Roads and Maritime Reference: SYD17/00445/02 (A18078222)  
DP&E Ref: SSD 8351

STAGE 1 CONCEPT PROPOSAL FOR THE DEVELOPMENT OF THE MARTIN PLACE  
PRECINCT  
NOTICE OF EXHIBITION OF EIS

Roads and Maritime has reviewed the submitted application and raises no objection to the Stage 1 concept proposal for the State Significant Development. Roads and Maritime provides the following comments for the Department's consideration in the determination of the Application:

Figure 13 Indicative access to new and existing service yards

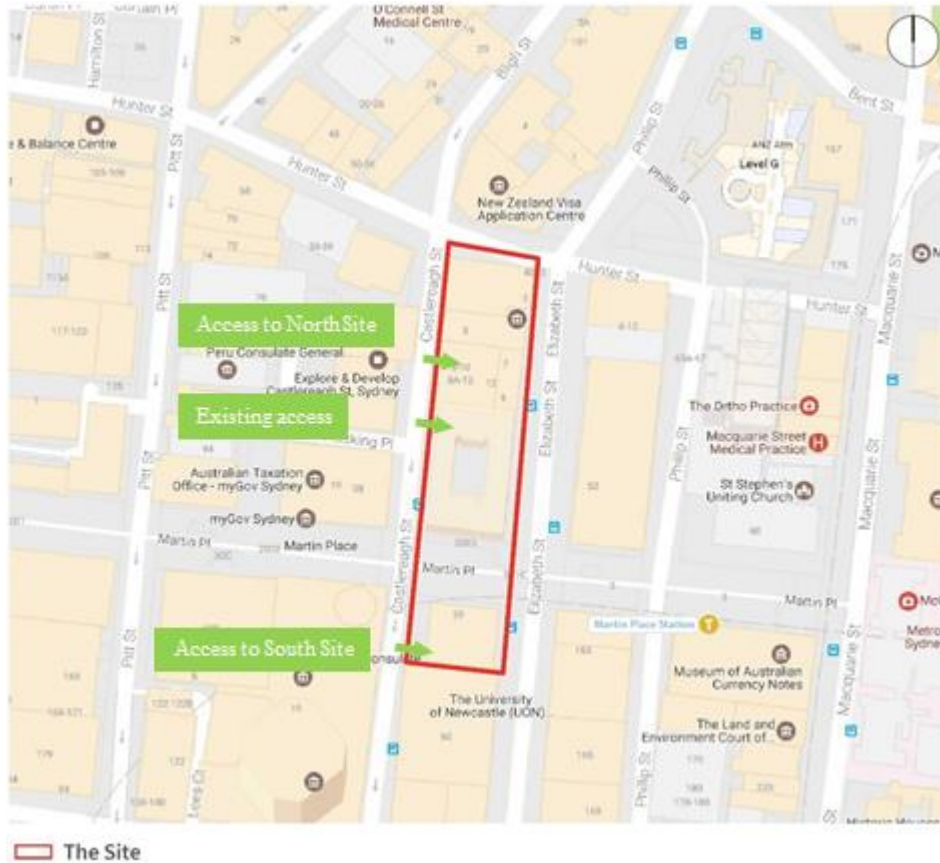
2. The proposed loading dock capacity should be adequate to cater for the full service vehicle demands of the ultimate development.
3. The proposed vehicular access points for the loading dock should be located as far as reasonably practical away from the traffic control signals on Castlereagh Street.

4. All vehicles should enter and exit the site in a forward direction. The swept path of the longest vehicle (including garbage trucks, building maintenance vehicles and removalists) entering and exiting the development, as well as manoeuvrability through the site, should be in accordance with AUSTROADS. In this regard, a plan shall be submitted to Council for approval, which shows that the proposed development complies with this requirement.
